# ENG-PUDSP22001-R2-TIS.pdf Markup Summary

Figure 2. Hillside at Lorson Ranch Site Plan

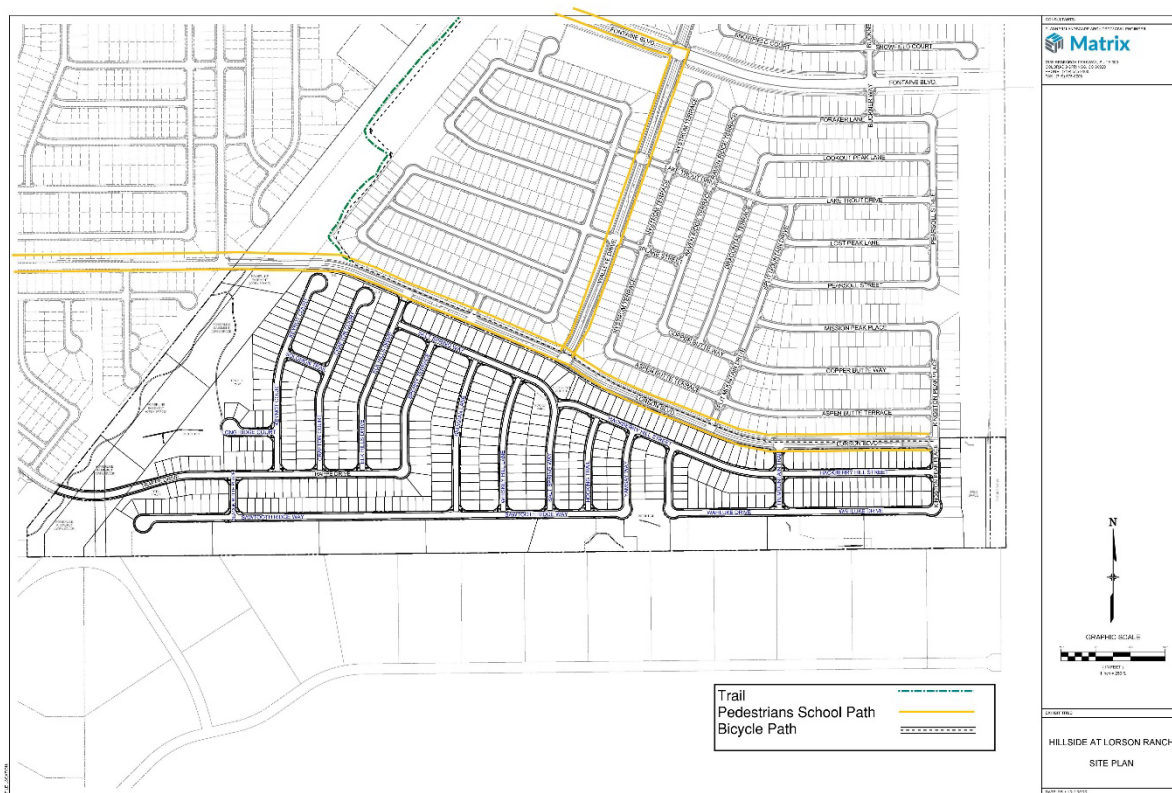
Show trail corridor, school pedestrian routes
